8 December 2020

RESPONSE TO OBJECTION FROM BLACKTOWN CITY COUNCIL - SSD-9368 – MODIFICATION 3 - STAGING - GALUNGARA PUBLIC SCHOOL (ALEX AVENUE)

Figure 9 D1T1 Operation with Joint Use car park in play (indicative illustration and detailing)

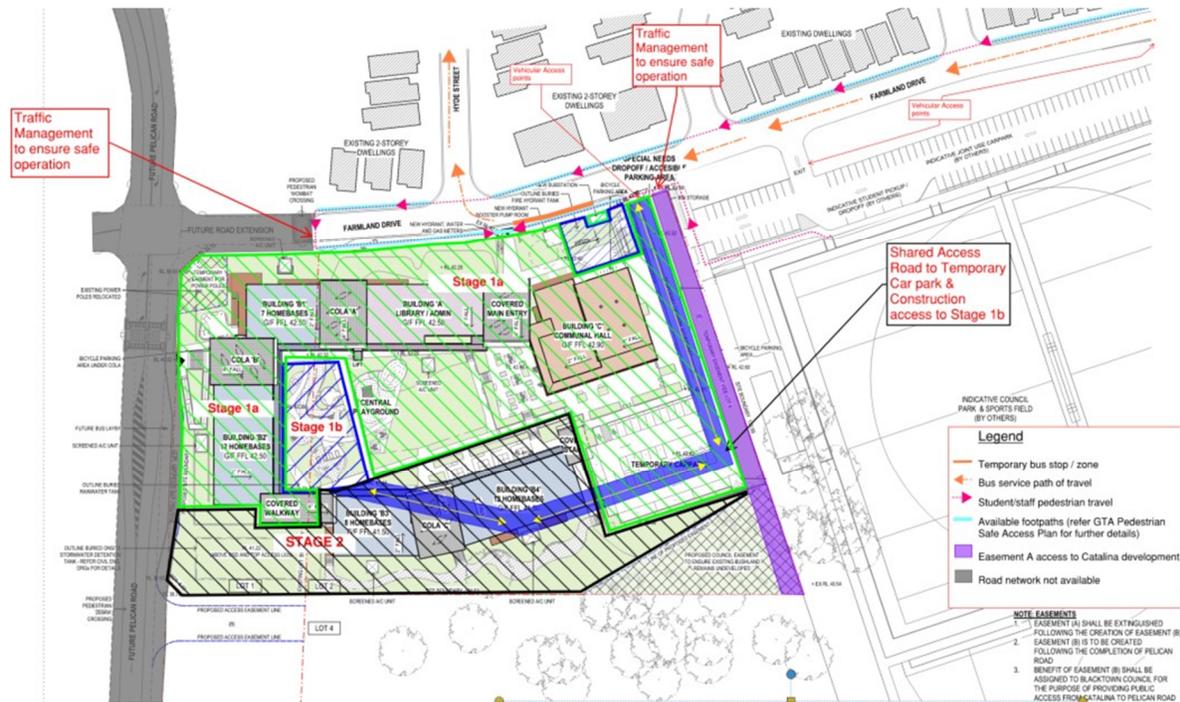
Traffic	It is noted that the Easement Management Plan refers to Disability Parking (Section 3.2.2). "Disabled parking available in the temporary carpark as illustrated in figure 9" however Figure 9 does not show any disabled parking spaces.	Figure 9 of the Easement Management Plan depicts the disabled in the NE corner of the temporary car park layout. This layout is also represented in Figure 2, 7 and 8 of the same documents for your reference.
Open infrastructure	Access to Easement A must not affect any existing trees required to be retained area. Easement A has been present prior to establishing the Council Easement for this development. This includes the proposed Council easement (bushland remains undeveloped easement) at the south end of Easement A.	Agreed. This is consistent with the requirements of SSD-9368 Consent conditions.
	Any impacts on trees to be retained near Easement A must be reported to Council in the form of an Arboricultural Impact Assessment (AIA). The AIA must provide tree protection measures to ensure no damage occurs to the trees within the easement.	Agreed. Any impacts on trees to be retained near Easement A would be subject to relevant authority approvals.
